M54 to M6 DCO Issue Specific Hearing and Compulsory Acquisition Hearing

Written Submissions of Oral Case on behalf of Allow Limited ('Allow')

Summary of Items Raised at Issue Specific Hearing 1 'Biodiversity and Cultural Heritage' 8th December 2020

Drawing Title
**FIGURE 8.15:
 BAT BASELINE – STATIC
 DETECTOR (2018 AND 2019)
 AND CROSSING POINT SURVEY
 (2019) LOCATIONS**

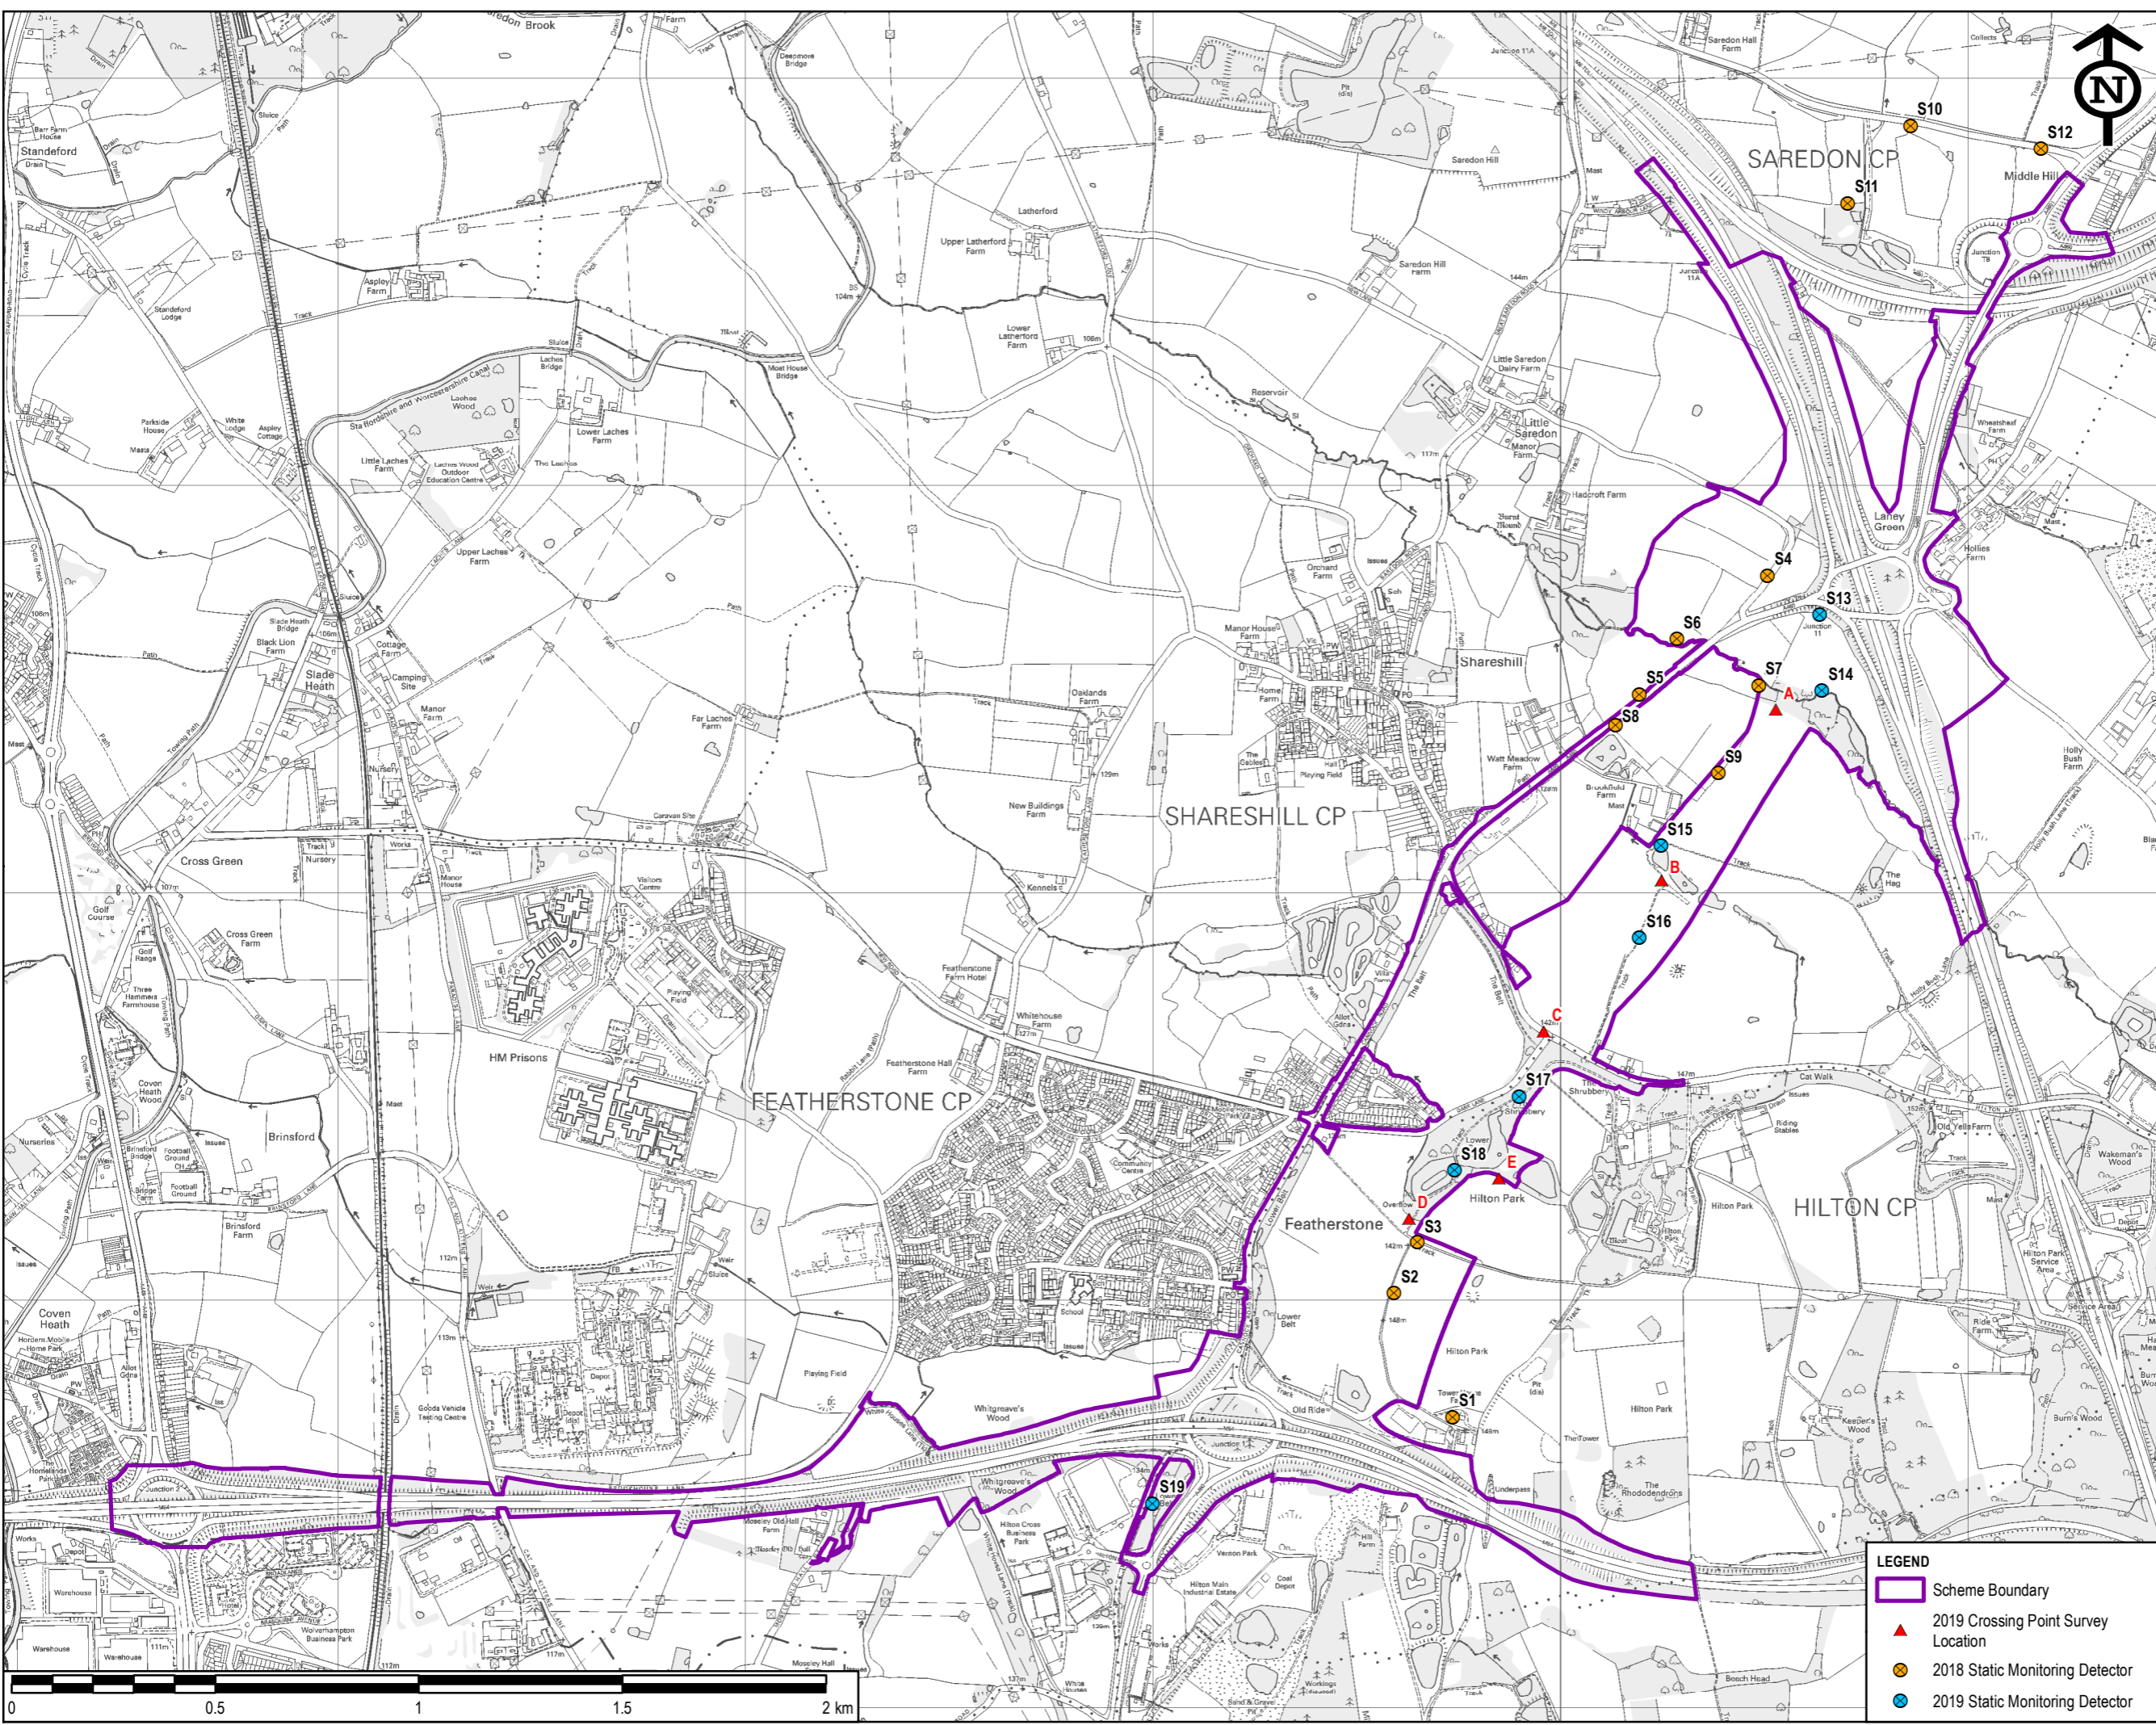
- (d) However, the area which will become Hilton Lane overbridge has already been shown through baseline surveys not to be a significant commuting route for bats (Crossing Point survey location C on Figure 8.15 of the Environmental Statement). This is key as bats are faithful to existing foraging routes and hence are unlikely to readily adopt a new route;

- (e) Crossing Point studies (Figure 8.15 and Paragraph 5.2.26 of Appendix 8.7) have shown that Hilton Lane is not a significant commuting route for bats. No Crossing Point surveys were undertaken at the southern end of Plot 5/2, despite low levels of bat activity being recorded. As such, it is not known if bats are crossing further south, from Lower Pools into the south-eastern corner of Plot 5/2. This has two implications for the scheme:

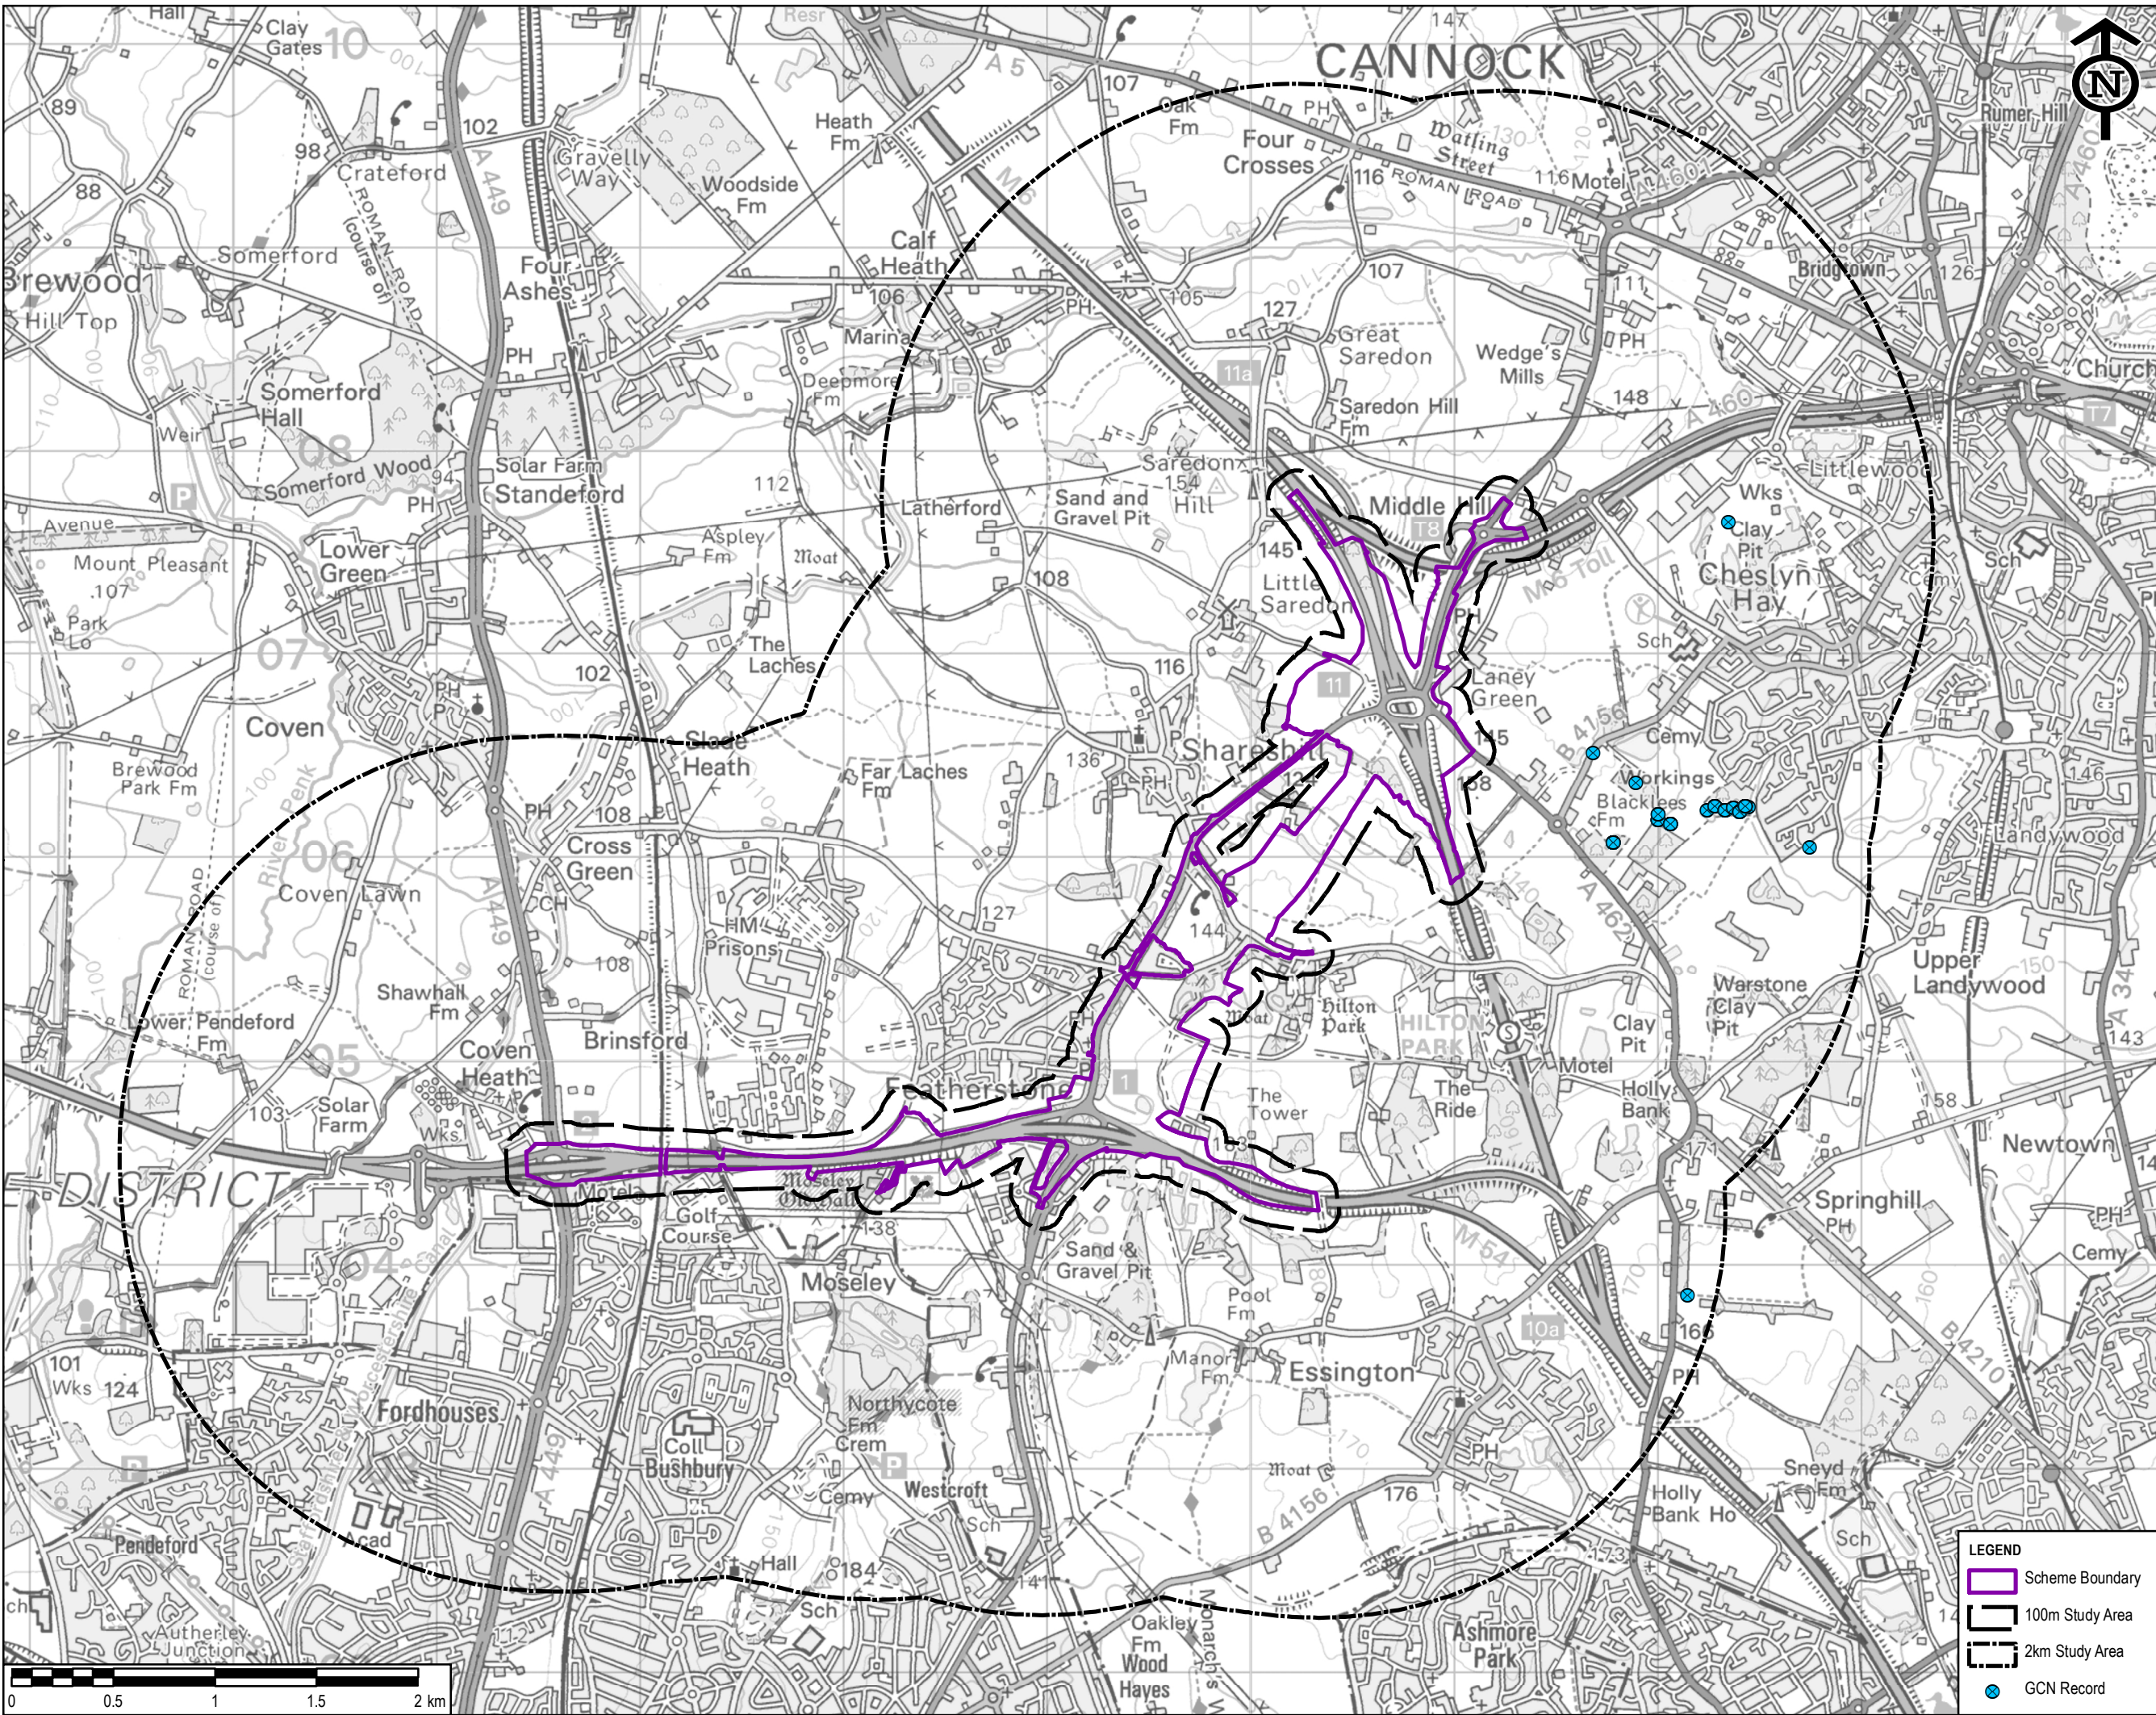
- (a) Figures 8.28 and 8.29 of the ES, plus the results obtained through the 2020 survey (Figure 8.35), show that historic, and current, known presence of Great Crested Newt is greatest to the east of the proposed scheme. However, compensatory 'ecological ponds' will be created to the west of the scheme.
